Department of Planning, Housing and Infrastructure

Our ref: SSI-10055-PA-75

Inland Rail Albury to Illabo (SSI-10055) Condition E108 – Approval of Stage 2 Urban Design and Landscape Plan, Condition E108

I refer to your submission requesting approval of the Stage 2 Albury to Illabo Urban Design and Landscaping Plan (UDLP), Revision 2, dated 11 November 2025, as required by Condition E108 of the Infrastructure Approval. I also acknowledge receipt of your responses to the Department's and the State Design Review Panel's (SDRP) review comments.

ELEVATION - TYPICAL TRUSS CONDUIT RETICULATION

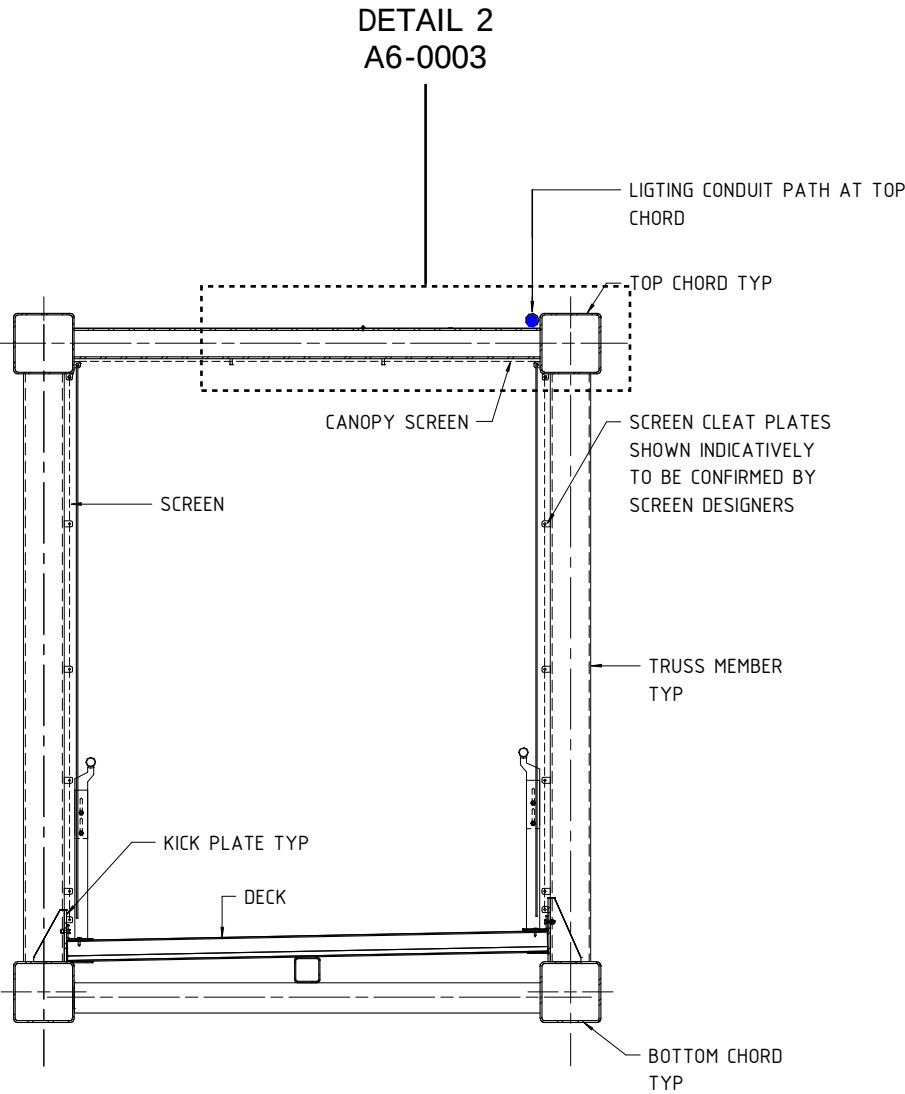
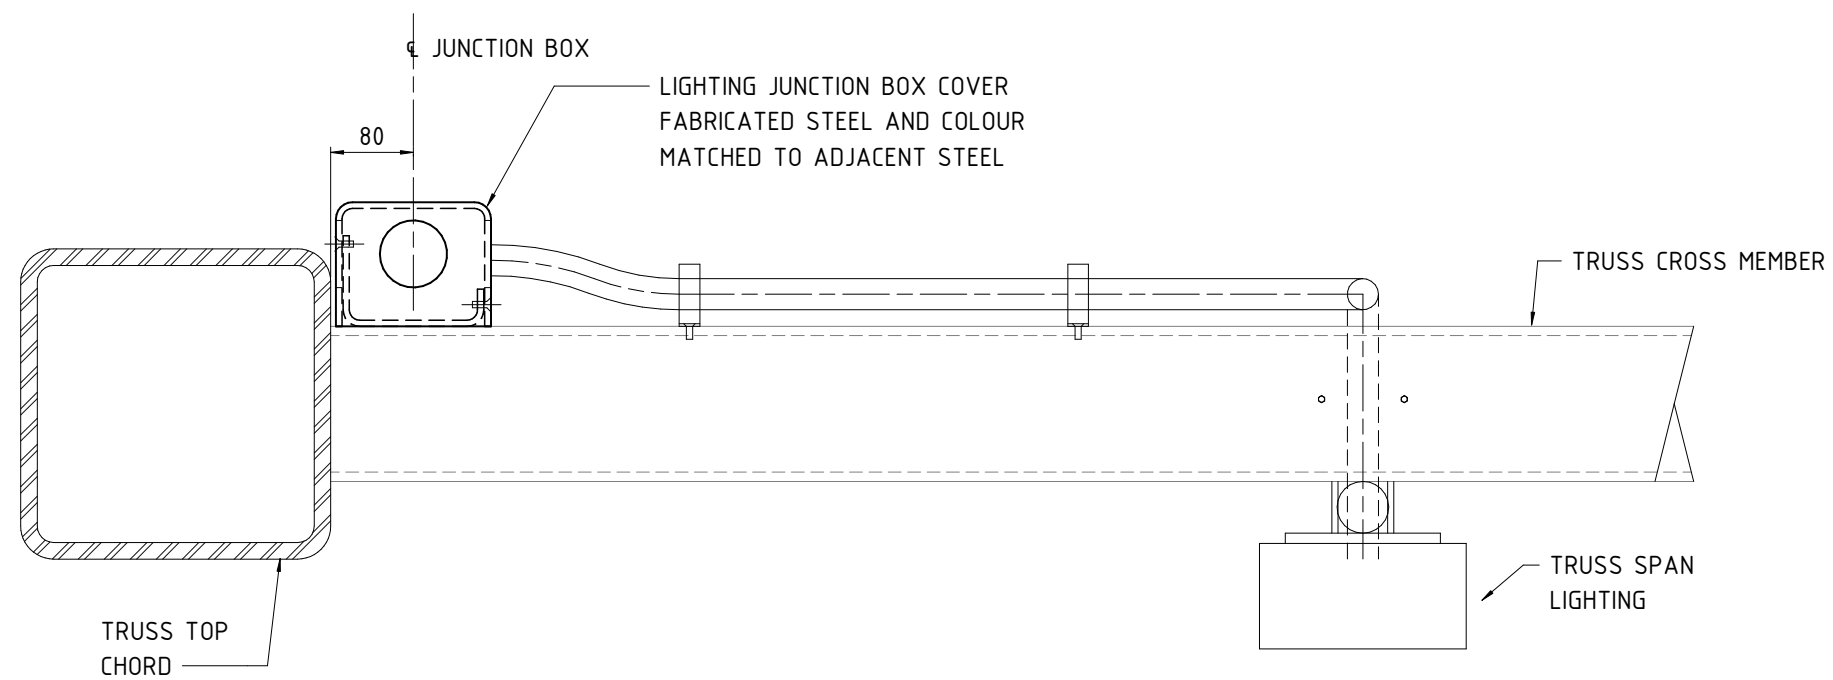
Ensure uniform detailing for conduit connections to light fittings at the top of posts, as shown in Sectional View 4 on Sheet A6-0005 (Appendix 6). For posts located on ramps, review Detail 5 on Sheet A6-0001 (Appendix 6) to extend the conduit closer to the junction with the light fitting.
